To: Planning Services  
From: Transport Development Management  
Date: 06/03/2024

**Application Number: S/24/0144**

**Proposal: Change of use of shop to restaurant (Class E(b)), installation of a flue and creation of a waste storage area.**

**Location: Ground Floor, 13 Manchester Road, Swindon**

Proposed Side Elevation
Scale 1:100@ A1

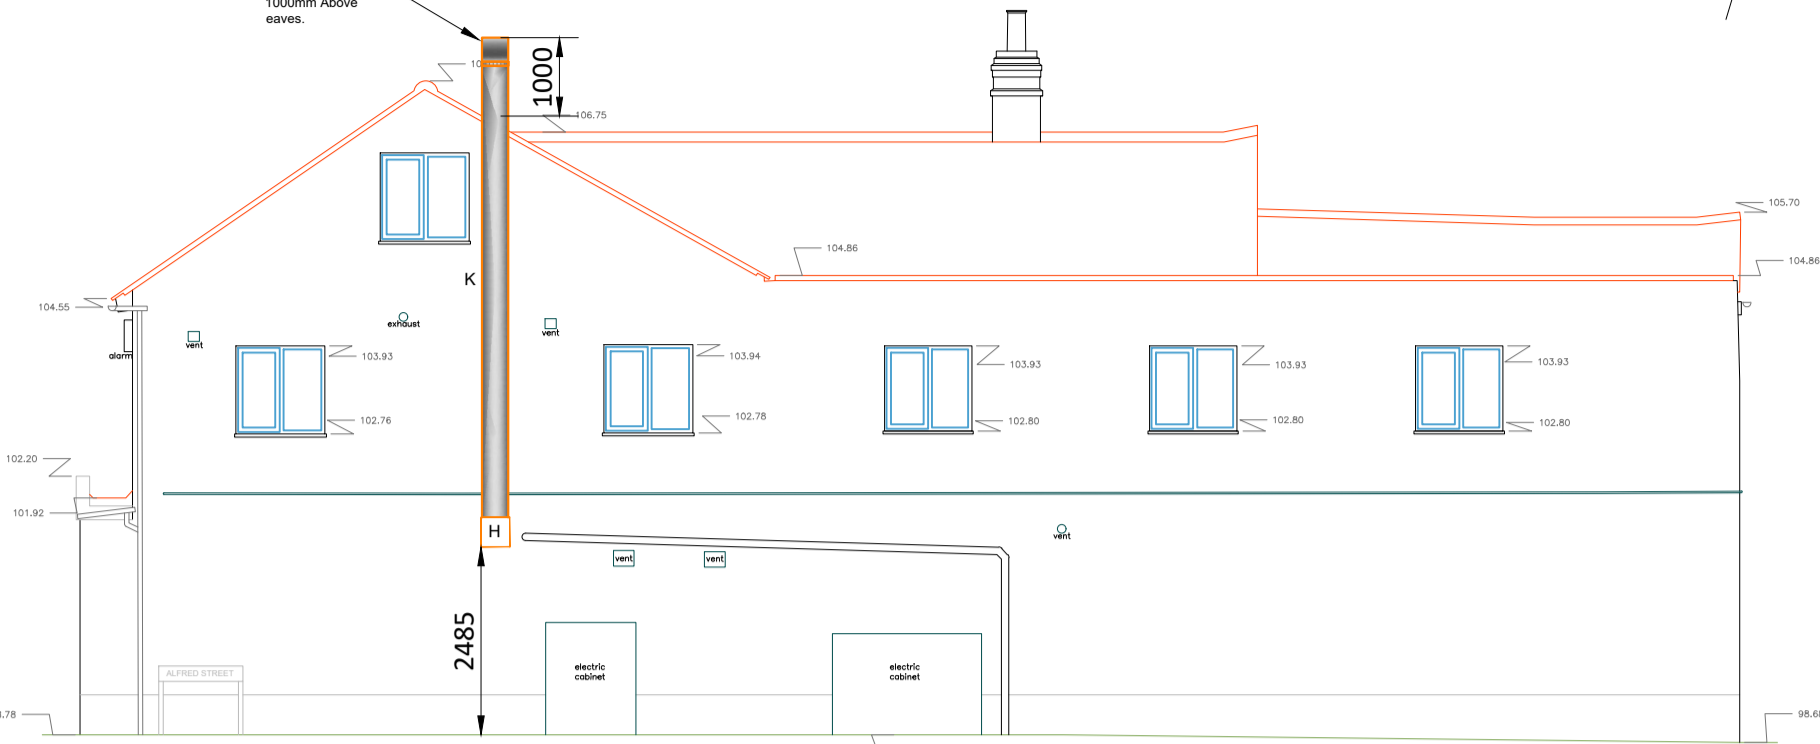
- **Overhanging Flue** – it is necessary to highlight that the proposed flue appears to overhang the public highway of Alfred Street and would therefore require an Overhang Licence to be granted by SBC/LHA.

However, the minimum clearance height for any element overhanging a public footway is 2.6m, and the flue is proposed with a vertical clearance of only 2.485m [as shown on the Proposed Side Elevation], resulting in the Overhang Licence application likely being refused. This vertical clearance is a safety issue in highway terms [particularly for cyclists] and must therefore be resolved before Highways would be able to support these proposals. It is acknowledged that the PD&AS identifies other sites in the area that have flues [page 11, section 5.12], but the point of difference is that those flues do not overhang the public highway and remain wholly within their site boundaries. Consequently, it is necessary to recommend that these proposals be **Refused** until adequate revisions are submitted.

- Inadequate vertical clearance is provided between the flue and the footway posing a risk to public safety, contrary to the requirements of Policy TR2 of Swindon Borough Council's Local Plan 2026.
